From
THE MEMBER-SECRETARY,
Madras Metropolitan
Development Authority,
No.8, Gandhi-Irwin Road,
Madras-600 008.

Letter No. A1/28692/92

Dated: 1.4.1993.

Sub: MMDA - Planning Permission - ^{Regularisation} ~~Construc-~~
~~tion of residential building in Plot~~
No.24 at S.No.175 part of Villivakkam
Village - Approval - Regarding.

PLAN SHOWING THE REGULARISATION OF THE DWELLING FOR  
MR. A. V. RAMAKRISHNAN  
IN PLOT NO. 24, S. NO. 175 PT. LAKSHMI 3<sup>RD</sup> STREET,  
VILLIVAKKAM MADRAS - 600049 CORP DN. 33  
SCALE: 1" = 8' 0" (1:100)

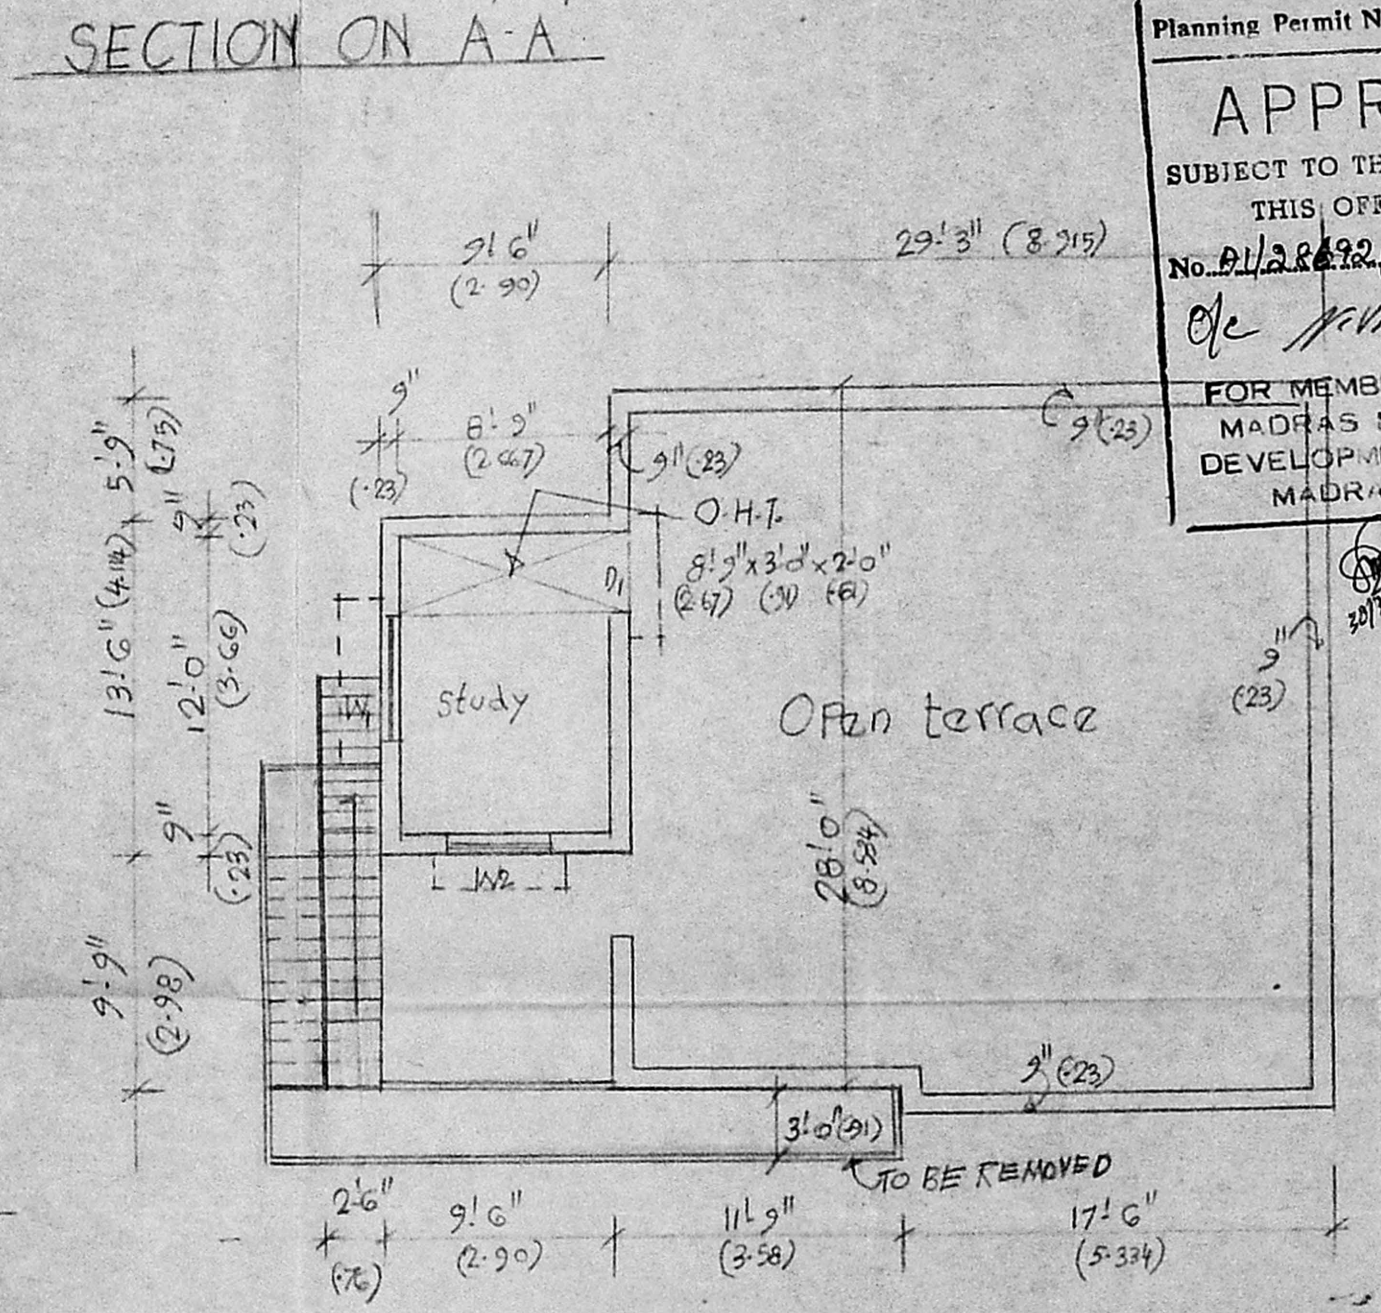
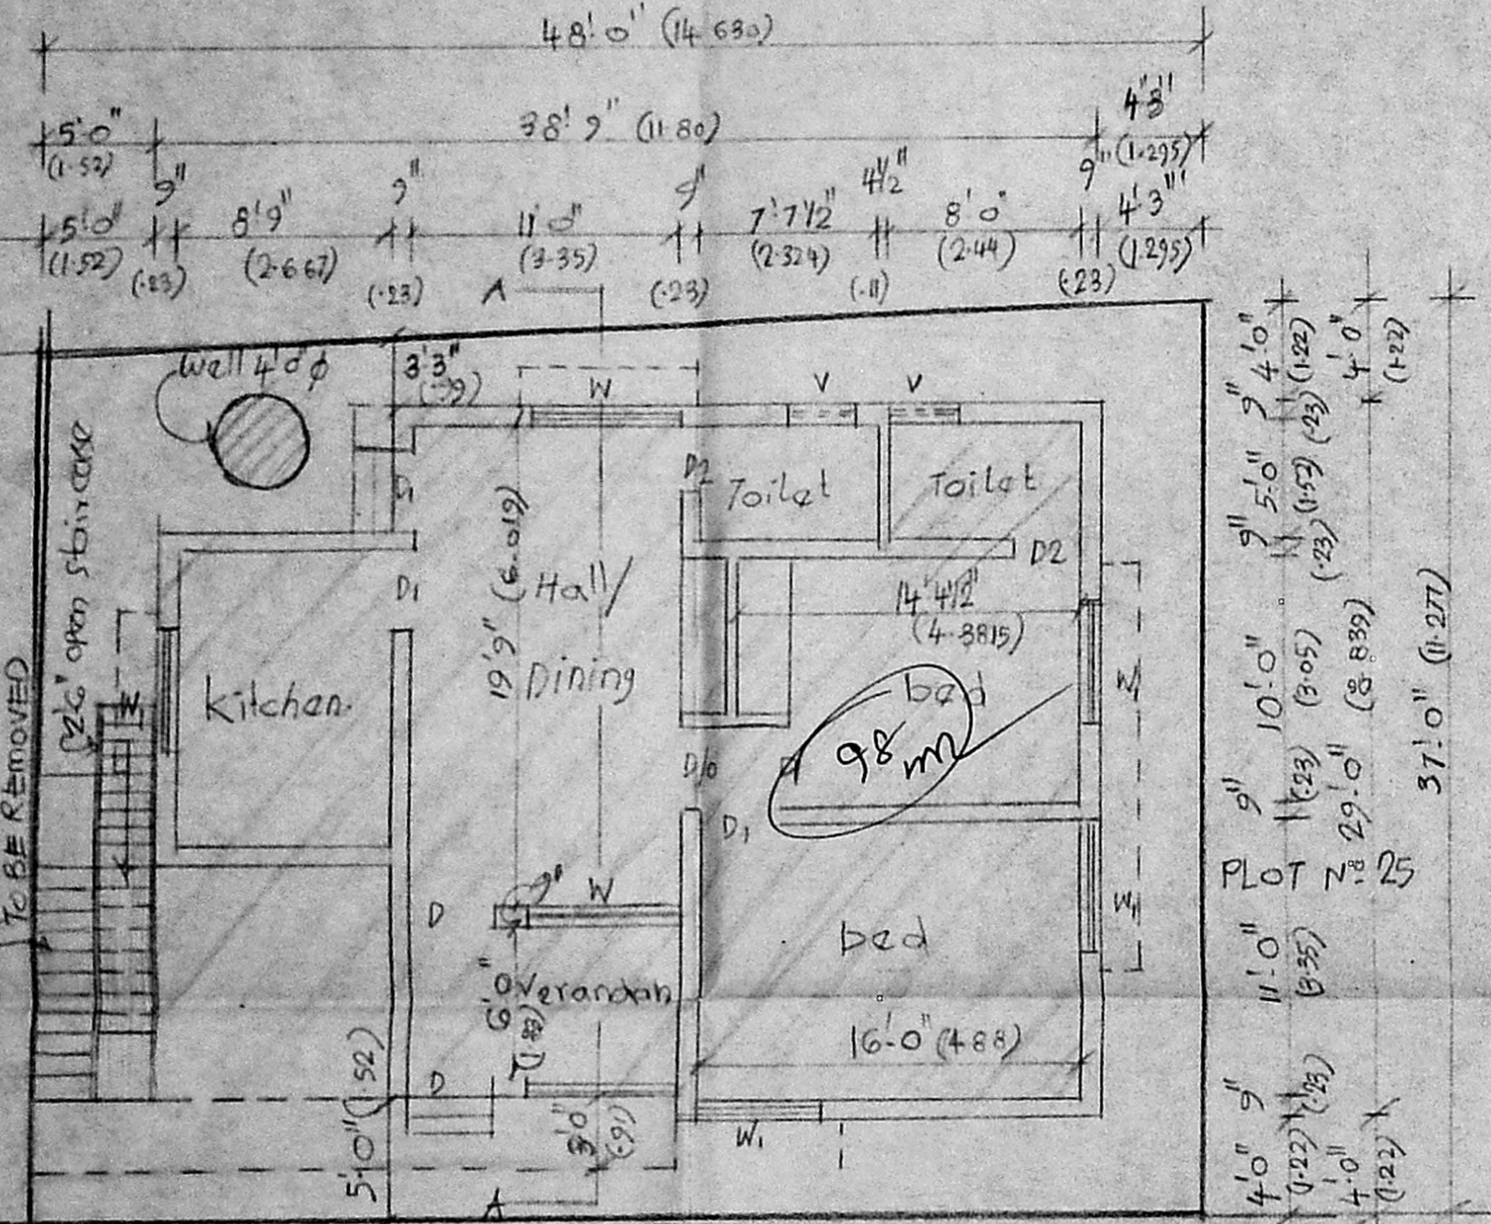
NOTE; Planning Permission has been issued subject to the condition of demolition of certain portion of the existing building. The portion shown in the yellow colour in the plan is to be demolished before releasing approved plans. Hence, you are requested to issue Planning Permission after verifying actual demolition.
